From: Simon Davis
Sent: 16 November 2020 12:52
To: Daniel.OShea [REDACTED]
Subject: FW: P/97/20/PL- Land To North Of Summer Lane Pagham

From: Laura Gibbons <Laura.Gibbons@arun.gov.uk>
Sent: 16 November 2020 12:01
To: Planning.Responses <Planning.Responses@arun.gov.uk>
Cc: Simon Davis <Simon.Davis@arun.gov.uk>
Subject: P/97/20/PL- Land To North Of Summer Lane Pagham

Engineers Comments On Surface Water Drainage

Drawing Title
Proposed Site Plan
105 Unit Scheme

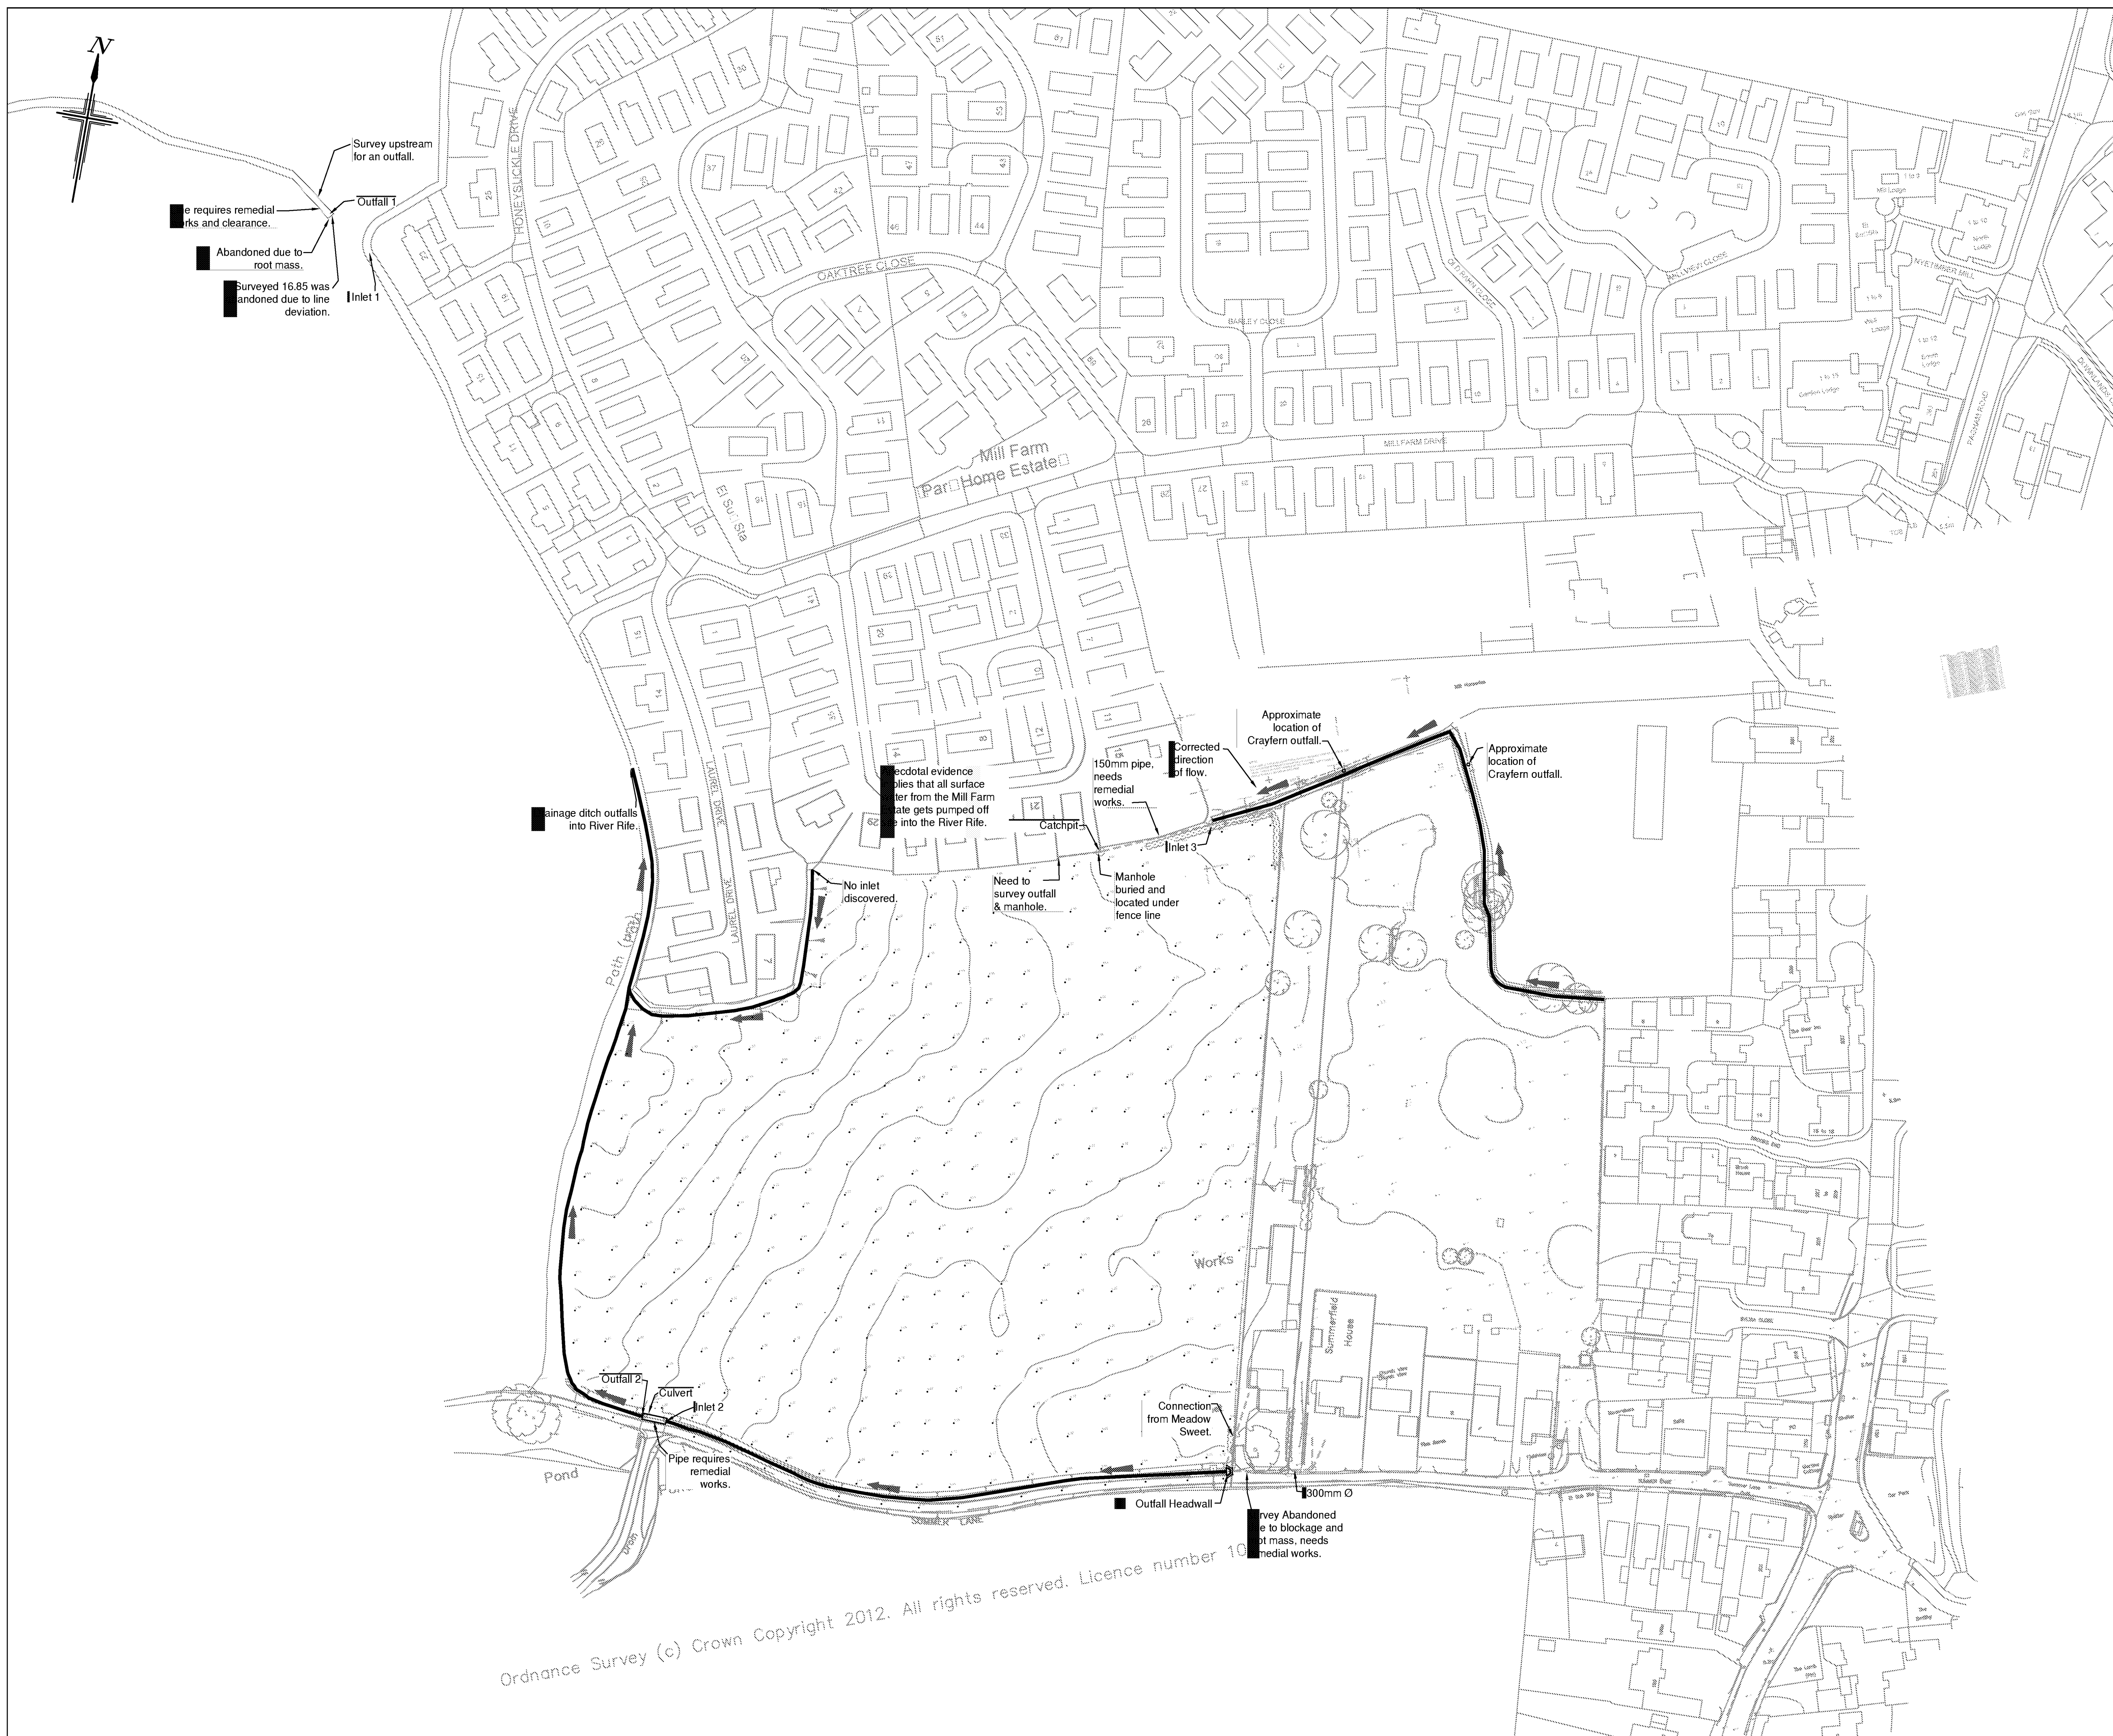
The proposed revised plans will result in an increase in ditch crossing points. A matter that we raised on the original proposals. We believe that the increased crossings will lead to a deterioration in the condition of the watercourse. Loss of daylight, loss of habitat and significant restrictions upon access for maintenance will likely result in ecological detriment and an increase in flood risk. We therefore do not support this proposed change in plan and would request that the number of ditch crossings is reduced.
